CITY OF ALBUQUERQUE

**RE: Multi-Specialty Clinic
Grading and Drainage Plan
Engineer's Stamp Date 11-20-2015 (File: M15D026B)**

RE: Multi-Specialty Clinic Grading & Drainage (File M15-D026B)

ENGINEER'S SEAL	MULTI-SPECIALTY CLINIC 2901 TRANSPORT ST, S.E. STORM DRAIN DETAILS	DRAWN BY DY
		DATE 11/06/15
		2015044-SD DETAILS
JOEL D. HERNANDEZ P.E. #17893	 TIERRA WEST, LLC 5571 MIDWAY PARK PLACE NE ALBUQUERQUE, NM 87109 (505) 858-3100 www.tierrawestllc.com	SHEET # SD-2
		JOB # 2015044

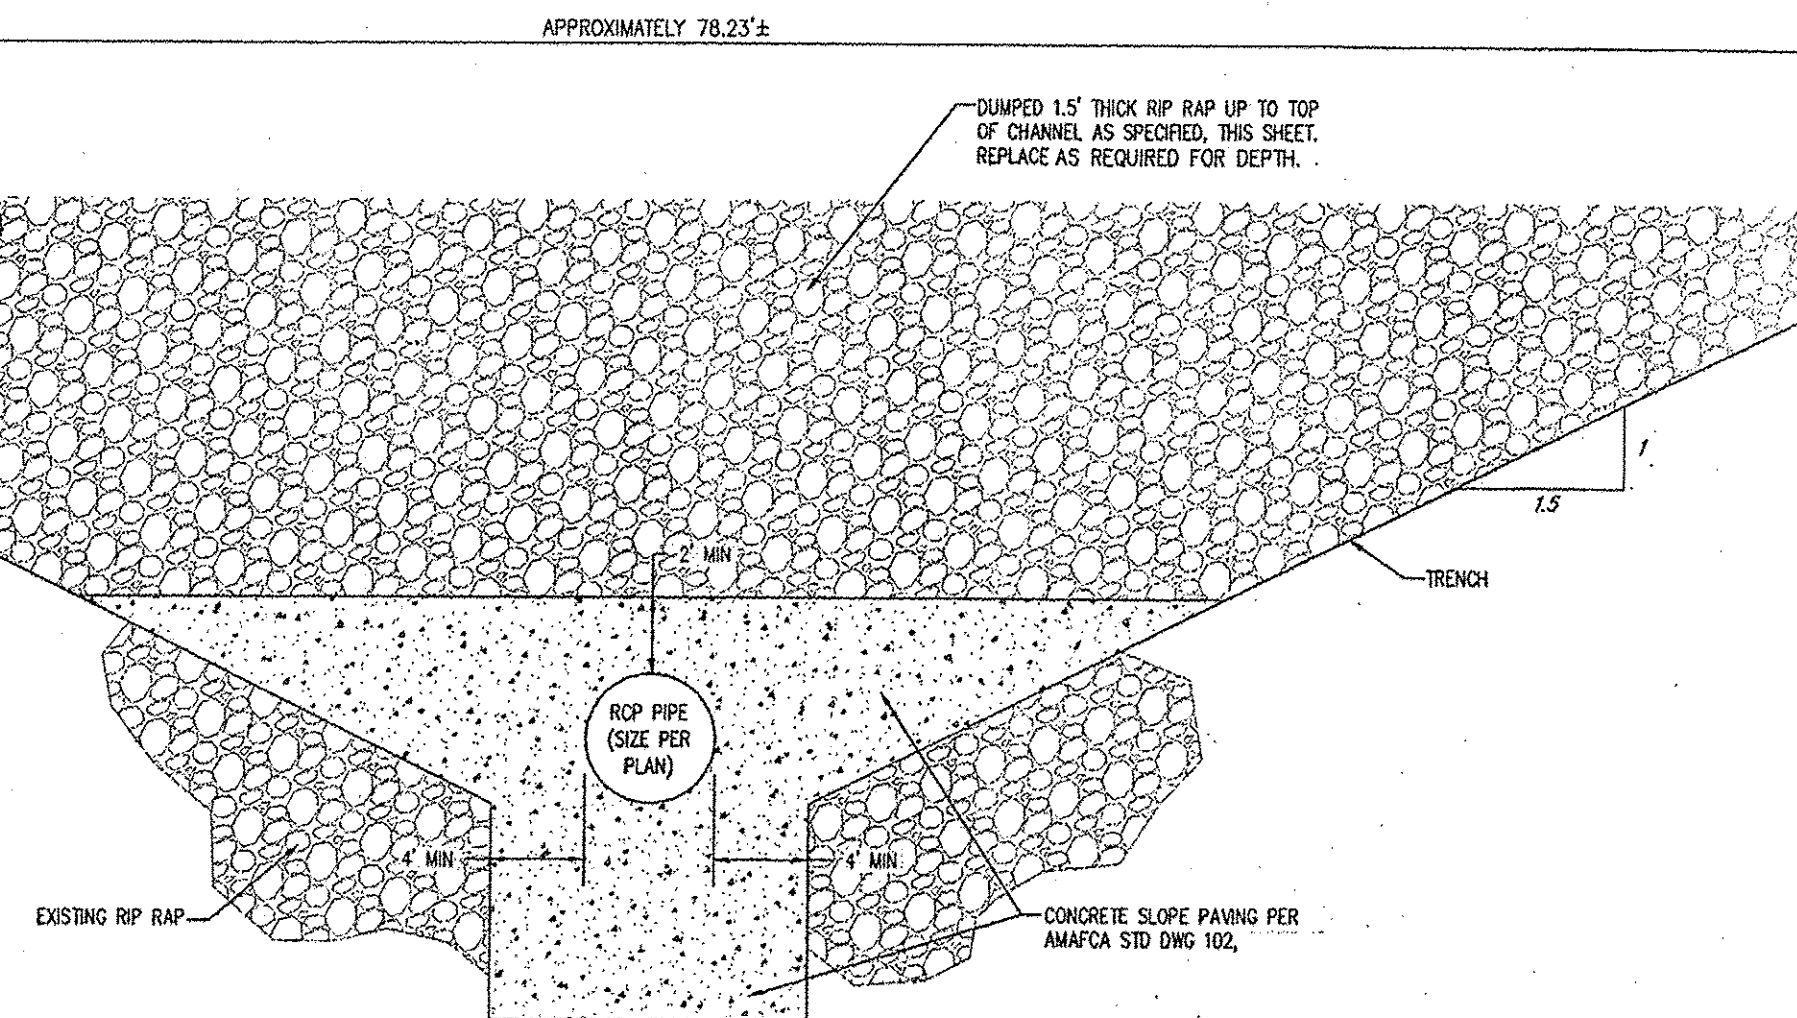
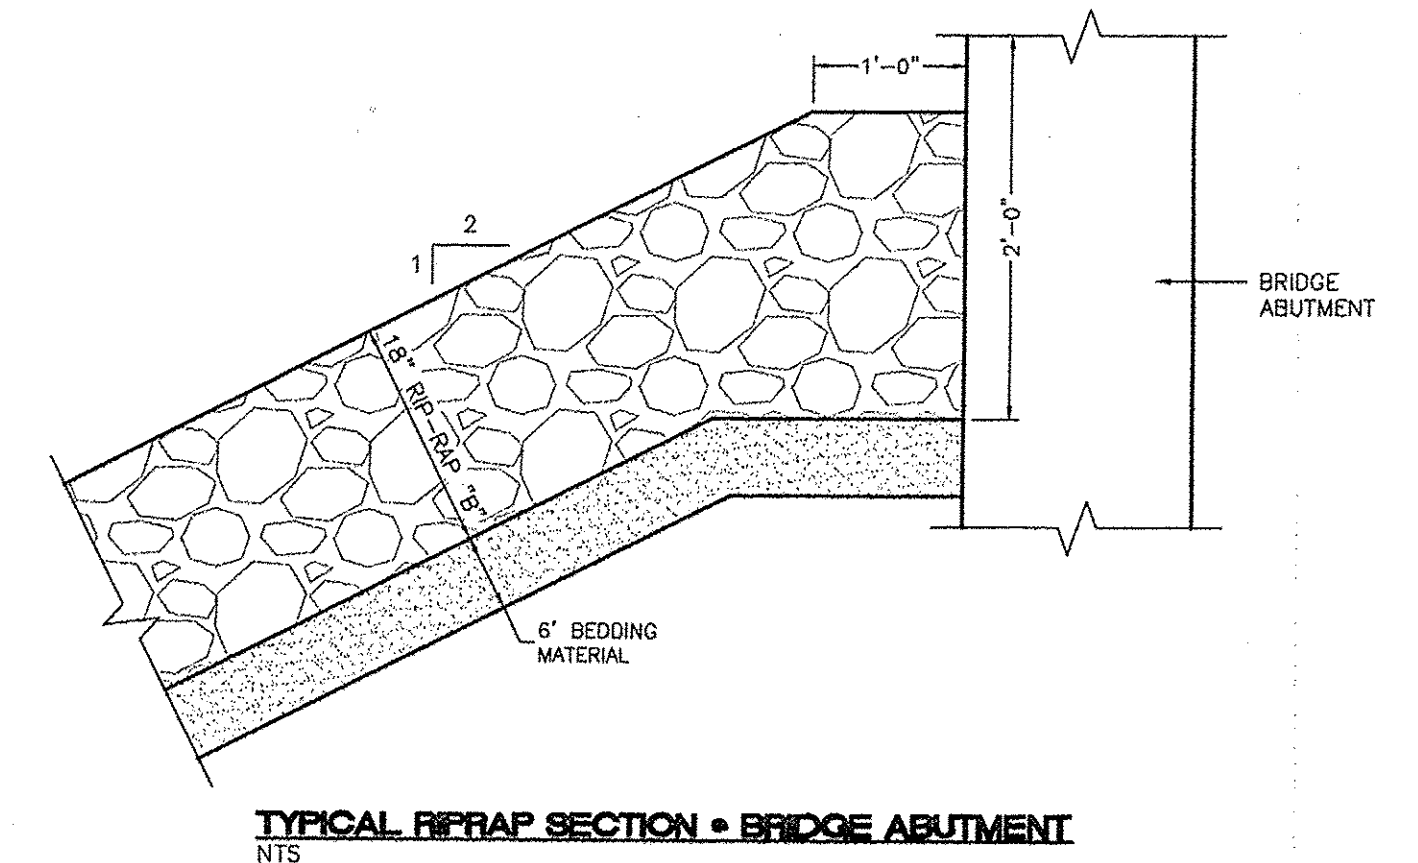
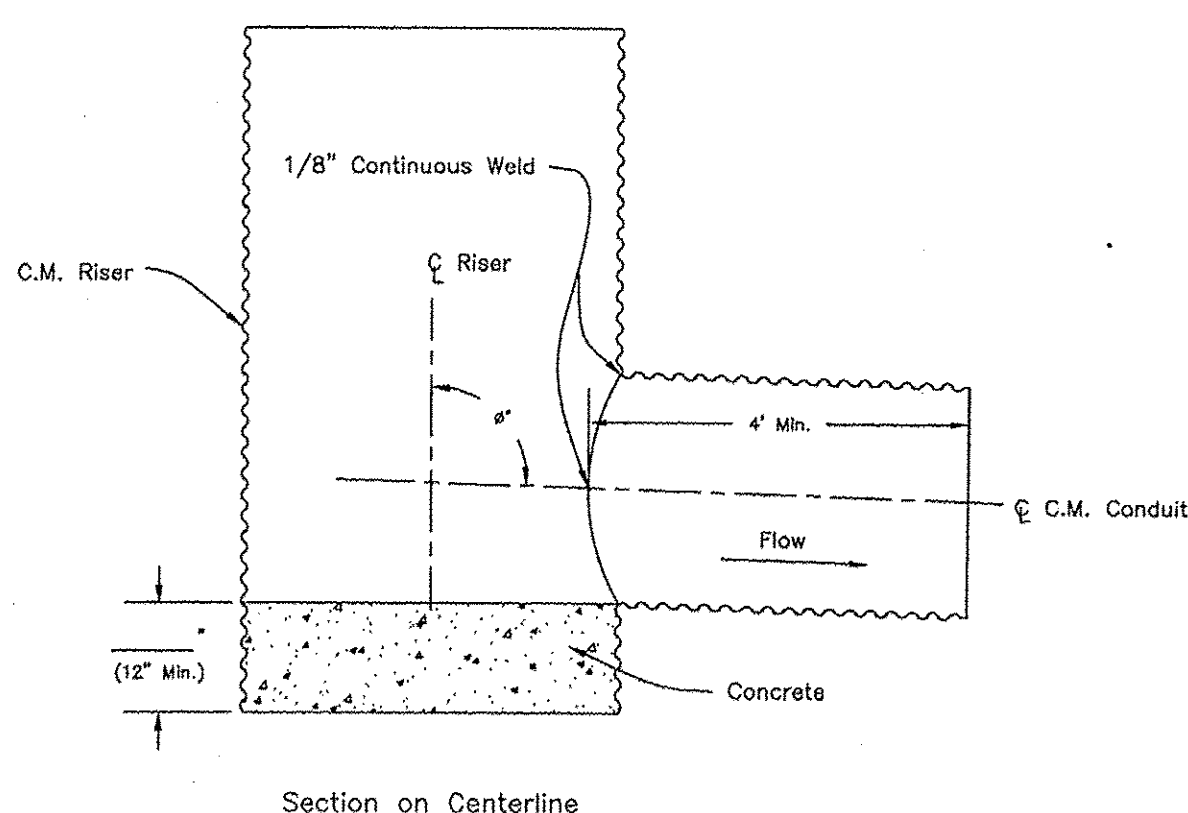
10. Sheet GR-2 references the concrete flume detail on SD-2, but it is not shown. Also, adjust the capacity worksheet to match the dimension (4' bottom width) shown on the plans.

Response: We have added the concrete flume detail to sheet SD-2 and included a revised capacity worksheet to match the 4-foot bottom width dimension as shown on the plans.
